DEPARTMENT OF PUBLIC WORKS

MEMORANDUM

TO: All Staff
FROM: Public Works Plan Review Team
DATE: October 27, 2021
SUBJECT: LPF-21-00012 Palomino Fields Div. VIII

Surveyed by LKH Scale 1" = 300'
 Drawn by Tml/FCS Sheet 1 of 4
 Checked by RNS Project No. 18146

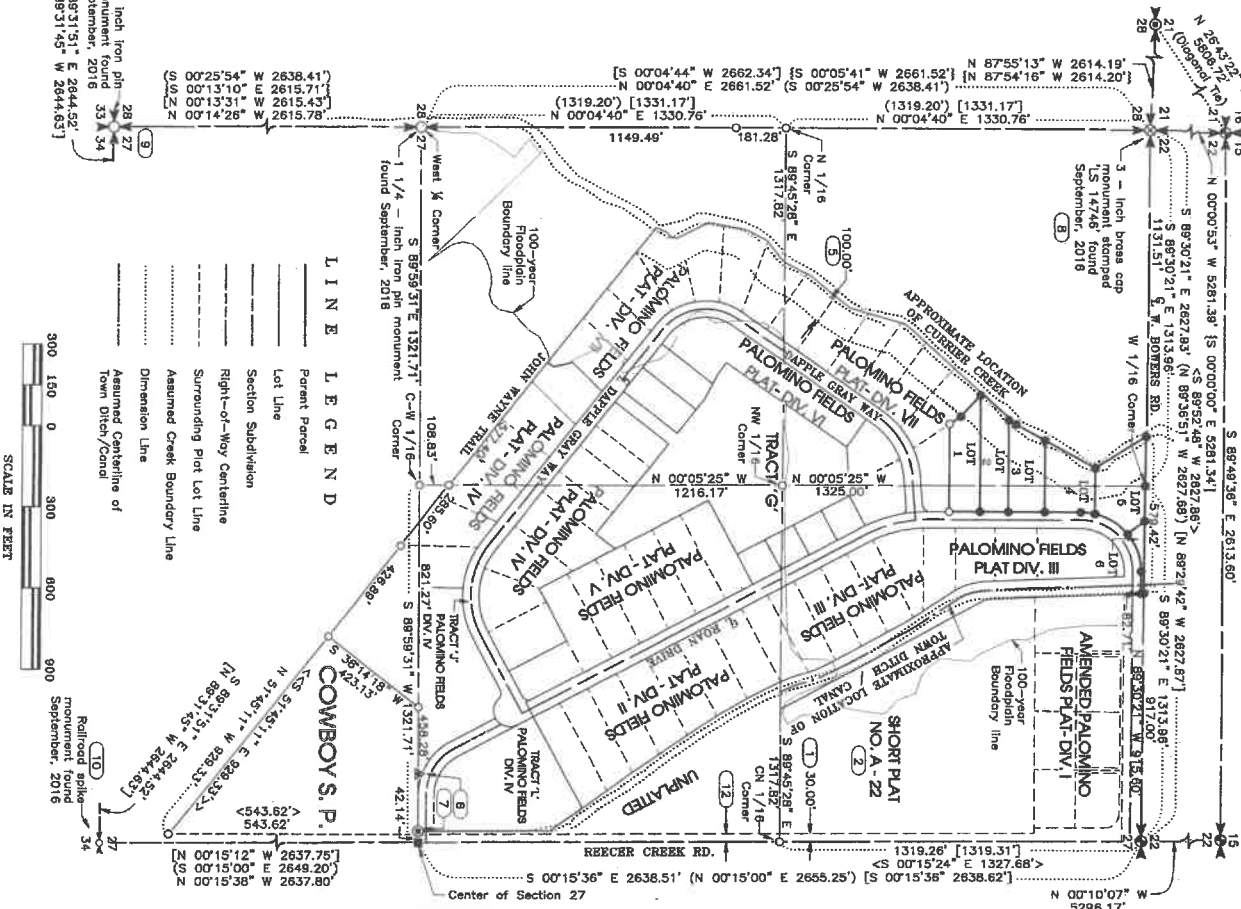
2. The text "C/L W. Bowers Rd." incorrectly appears on the N line of Nw1/4 Nw1/4 Sec 27.

Surveyed by LHM Scale 1" = 60'
 Drawn by Tml/FCS Sheet 2 of 4
 Checked by RNS Projed No. 18146

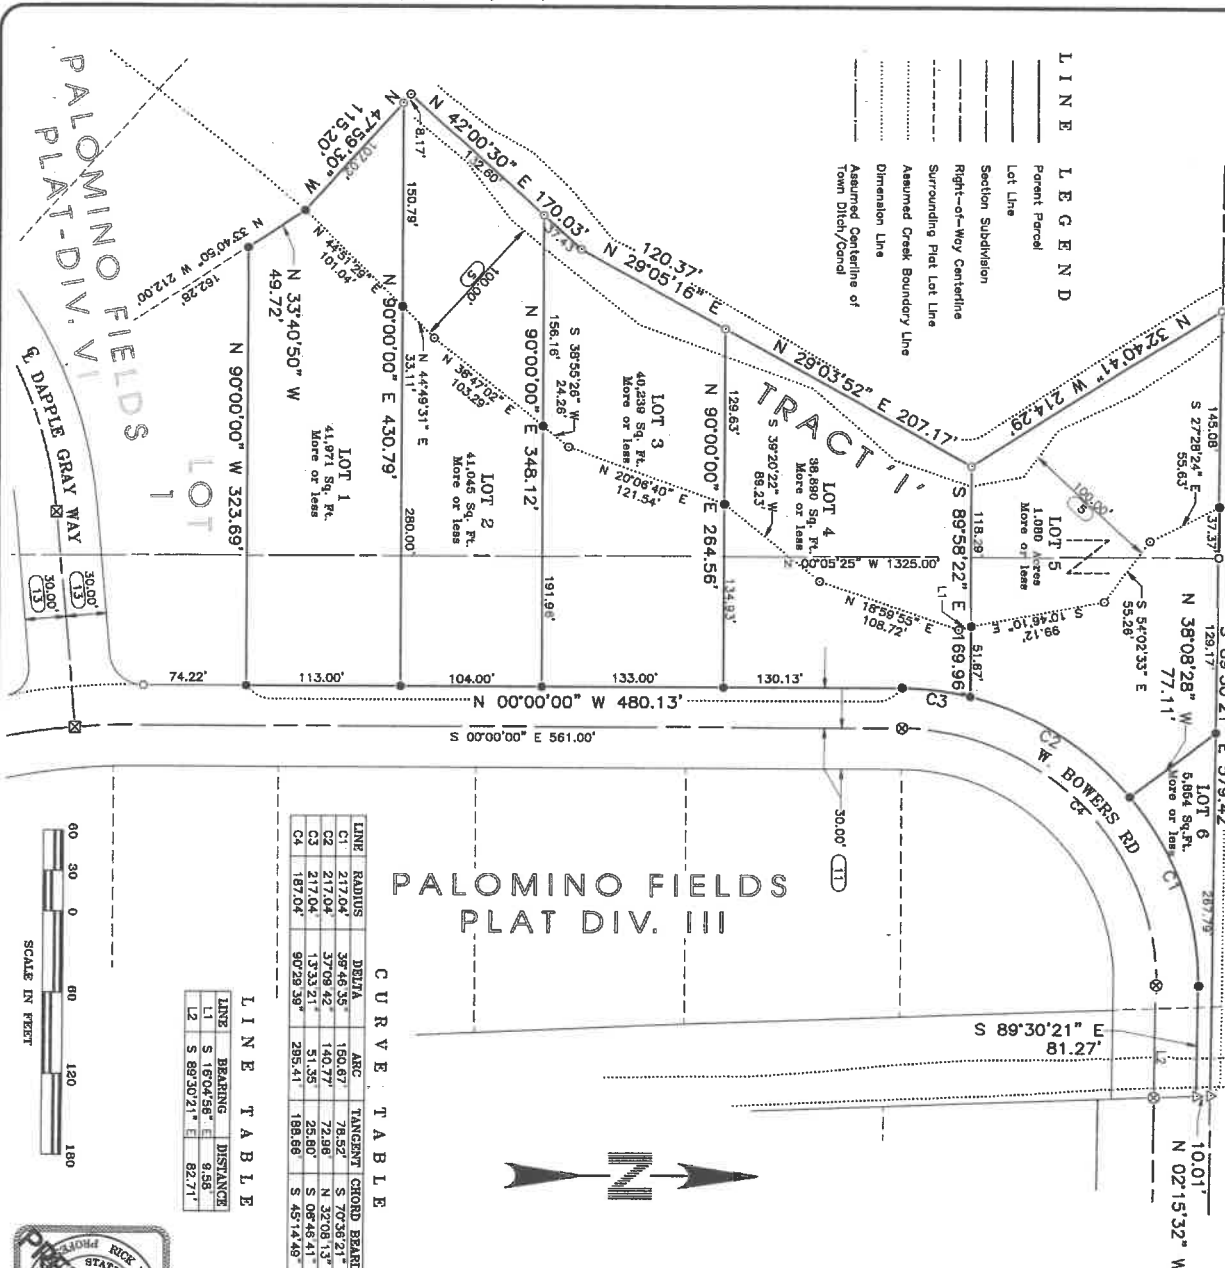
3. The last line in the Legend should be changed to "See Plat Notes – See sheet 3 of 4"
